Our ref: HA/2022/123943/01-L01
Your ref: LU/18/22/PD
Date: 21 February 2022

NOTIFICATION FOR PRIOR APPROVAL UNDER SCHEDULE 2, PART 3, CLASS MA FOR THE CHANGE OF USE FROM COMMERCIAL, BUSINESS & SERVICE (CLASS E) TO 1 NO DWELLING HOUSE (CLASS C3).

10 BAYFORD ROAD LITTLEHAMPTON BN17 5HL

Proposed Raised Floor Level to Front

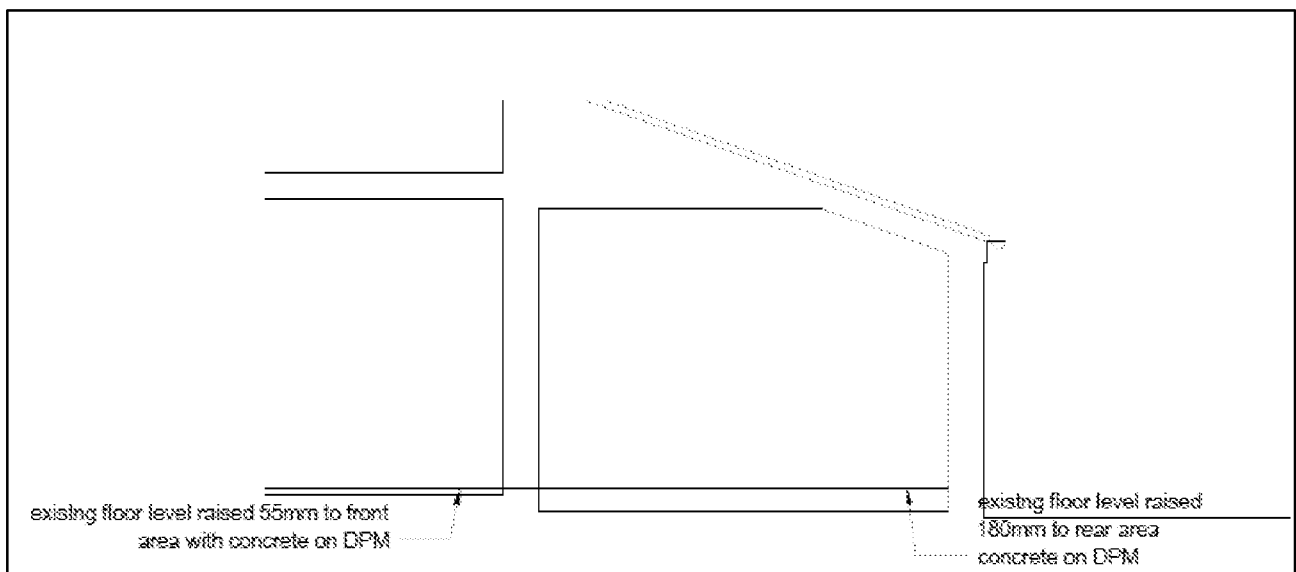
The submitted FRA does not comply with the requirements for site-specific flood risk assessments, as set out in paragraphs 30 to 32 of the Flood Risk and Coastal Change section of the planning practice guidance. The FRA does not therefore adequately assess the flood risks posed by the development. In particular, the FRA fails to:

- Consider how tidal flooding will affect people and property
- Provide a comparison of undefended tidal levels to finished floor levels through which to consider flood risk to occupants
- Assess the impact of climate change using appropriate higher central and upper end allowances, see: 'Flood risk assessments: climate change allowances'

To overcome our objection, the applicant should submit a revised FRA which addresses the points highlighted above.
